PLANNING CONSULTATION RESPONSE

Application No	2026/0482
Proposal	Change of use of garage from domestic (Use Class C3) to be used as a commercial beauty salon (Use Class Ec2)
Address	18 West Crescent, Oxspring, Sheffield, S36 8YU
Date of Consultation Reply	24/08/26
Consultee	Highways DC

Site Layout - Proposed
18 West Crescent, Oxspring, S36 8YU

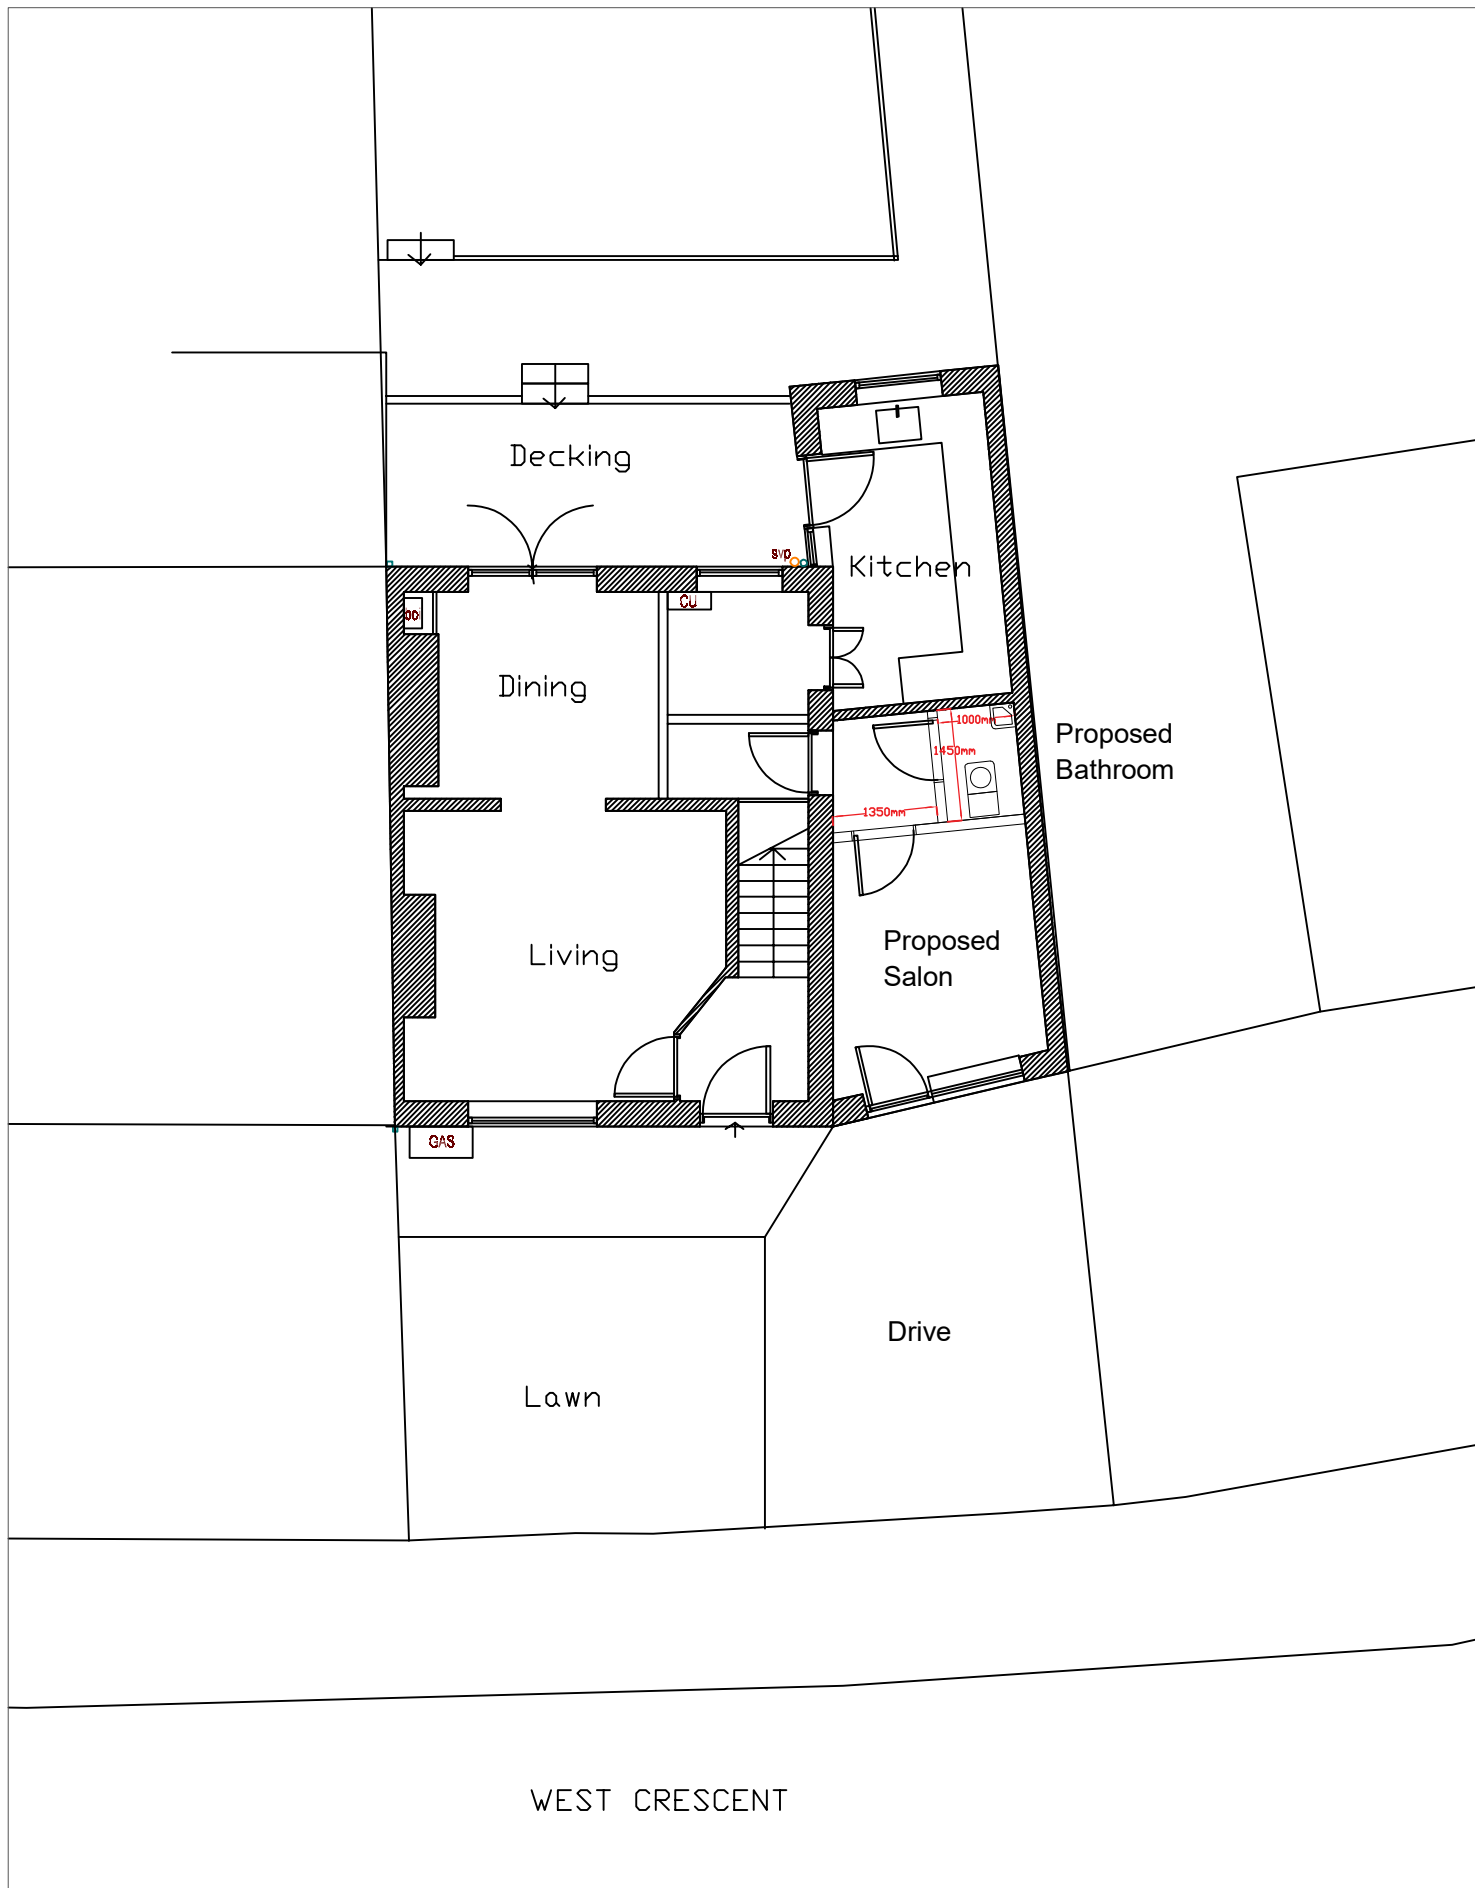
Further to previous comments an amended layout drawing now shows the driveway to be widened to 5.5m, allowing two vehicles to park.

The parking facilities as indicated on the submitted plan shall be surfaced in a solid bound permeable material (i.e. not loose chippings) and adequate measures shall be so designed into the proposed access to avoid the discharge of surface water from the site on to the highway.
Reason: To ensure adequate provision for the disposal of surface water and to prevent mud/debris from being deposited on the public highway and to prevent the migration of loose material on to the public highway to the detriment of road safety and in accordance with Local Plan Policy T4 New Development and Transport Safety
